Re: Great Connell SHD: ABP Reference: 313306.

Observation of Perry and Kate Whitworth, of 81 Wellesley Manor, Newbridge, Co. Kildare.

SITE LAYOUT PLAN—SHEET 1 @ 1:500

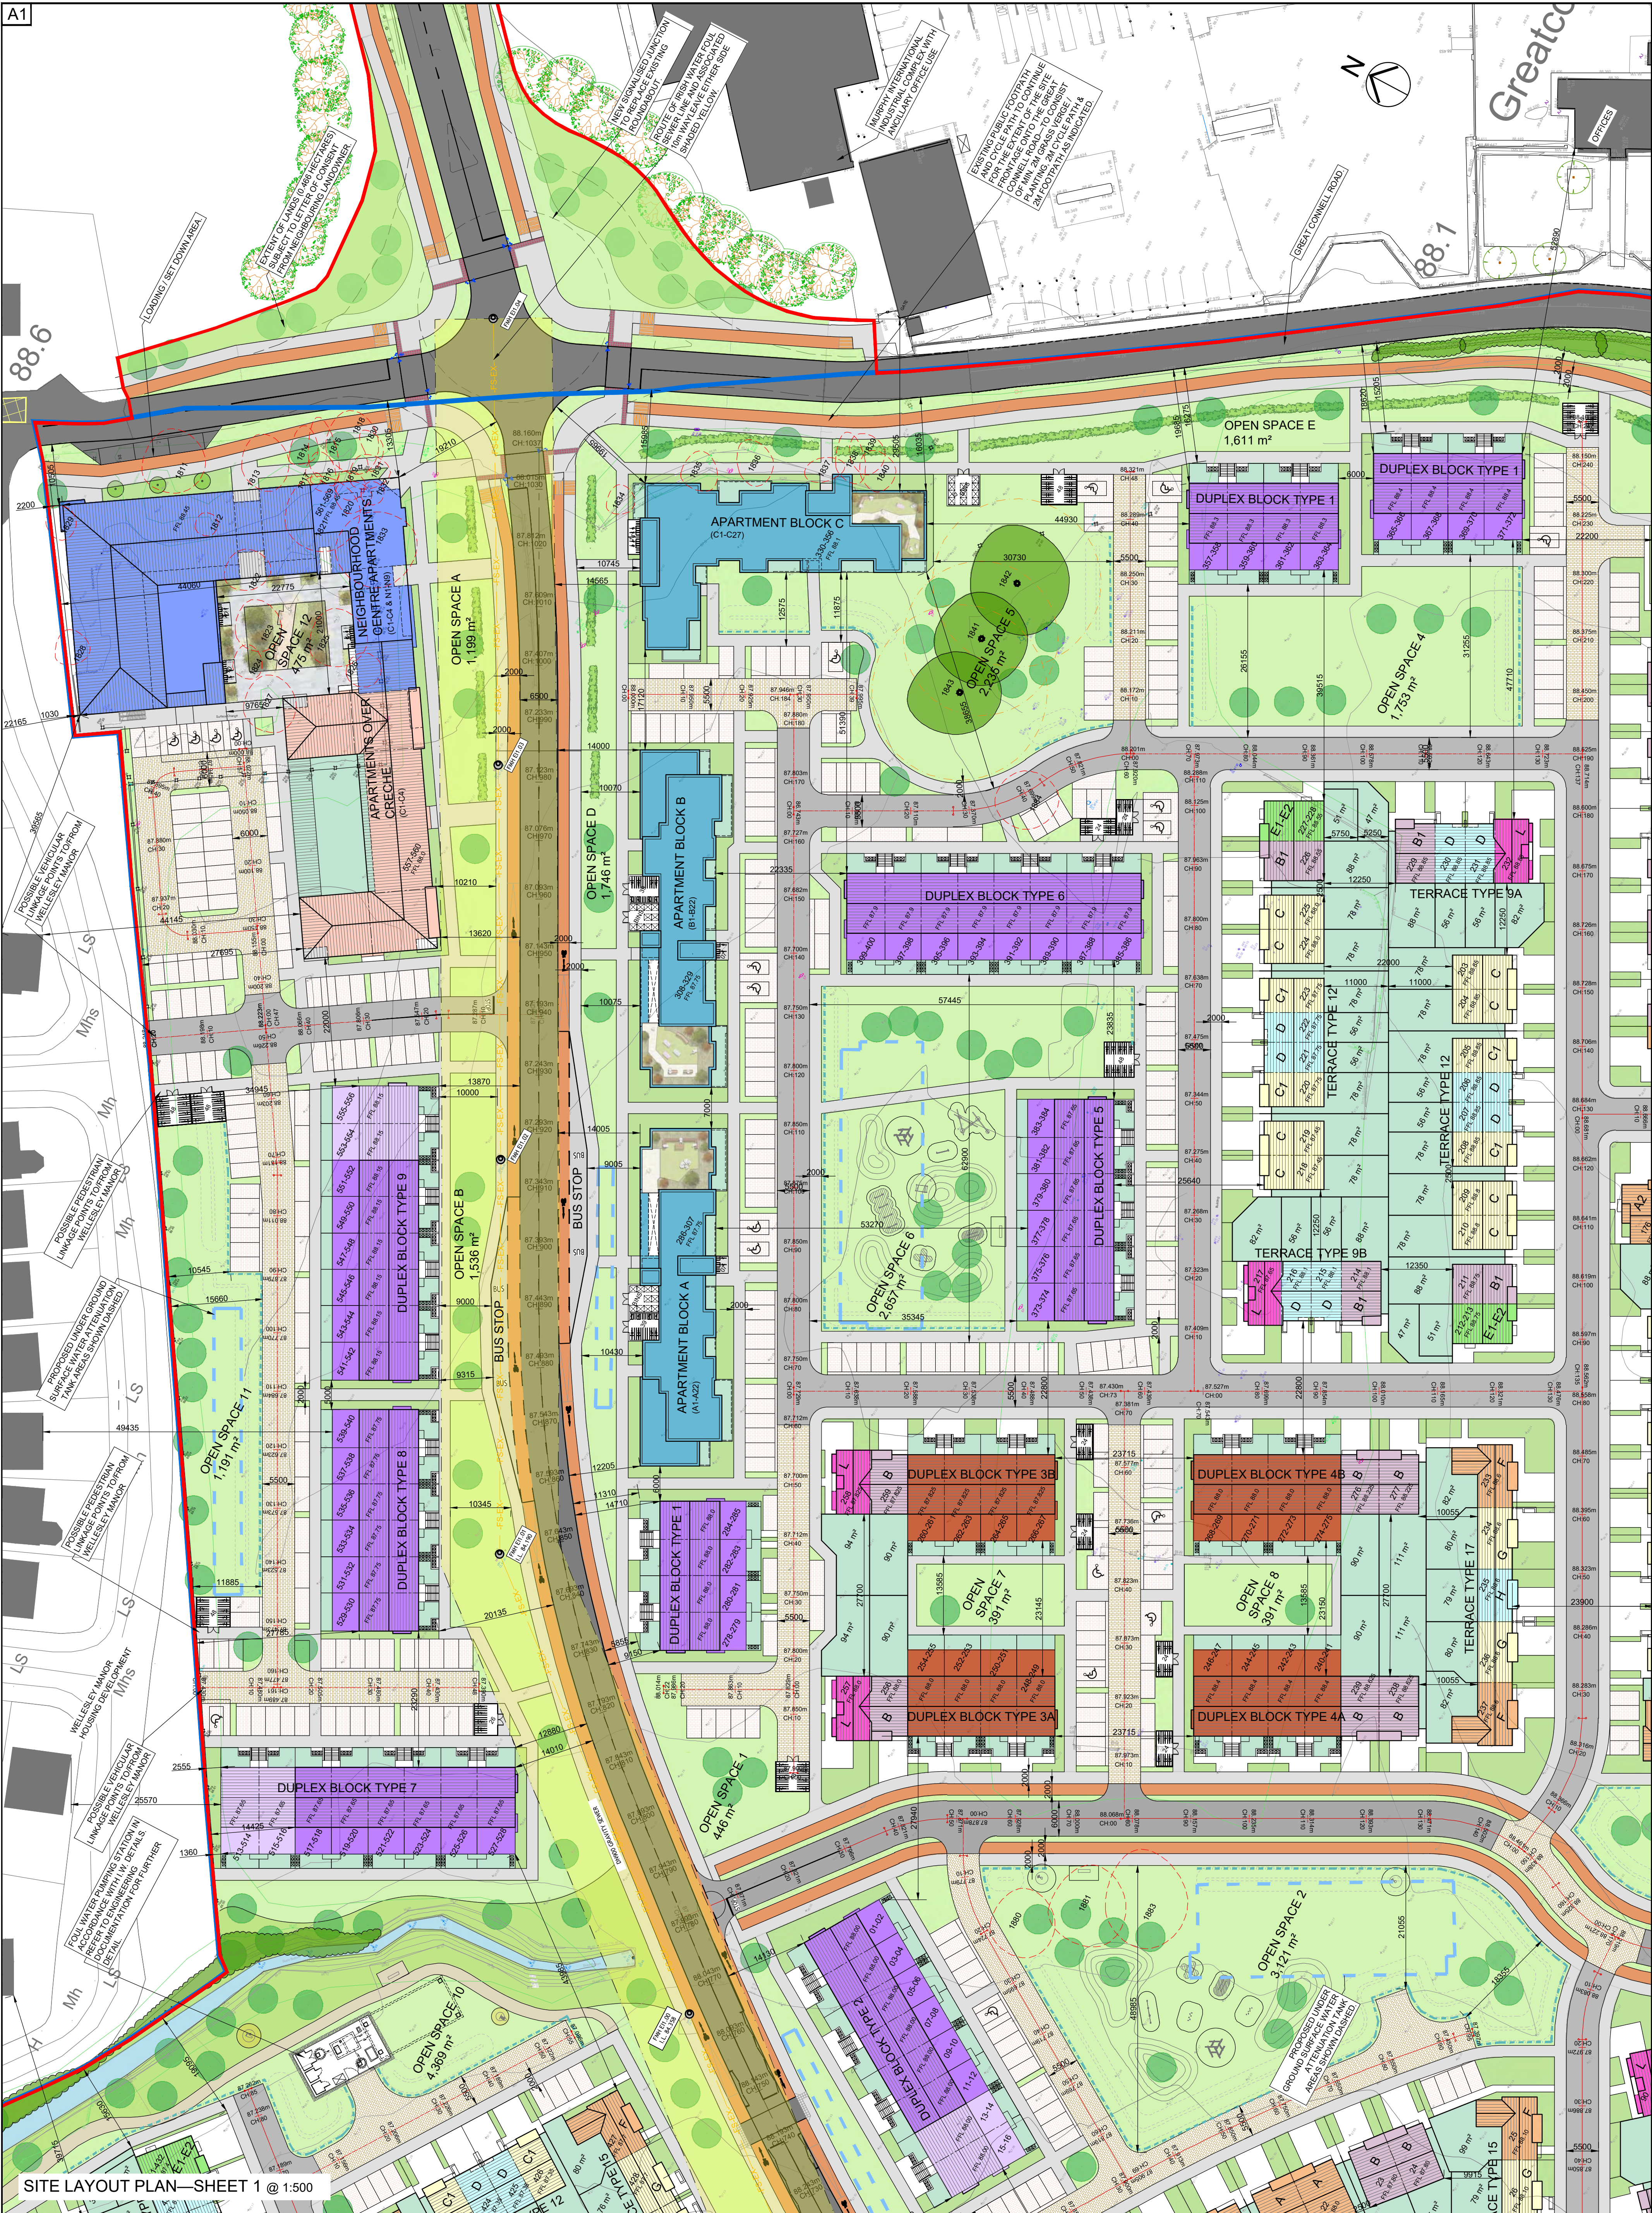
PA-003\_PROPOSED SITE LAYOUT PLAN-SHEET 1

We submit that there appears to be a discrepancy between the Proposed Site Layout Drawing and Section P-P (Part 1 of 2) in relation to the distance between Duplex Block 8 and the rear of the houses in Wellesley Manor: On the former, a dimension of 67330 is given, whereas we calculate the distance to be in the order of 53100. Should we be correct in this assertion, the representation of the proximity of the proposed development to the existing houses in Wellesley Manor is understated by over 14 metres: this is both significant for the owners in Wellesley Manor who may be relying on these drawings to ground their opinion on the scheme, but is also 'material' from a Planning perspective. It is unhelpful, and may be 'material' that the distance of Block 8 for the site boundary is not indicated on this drawing.
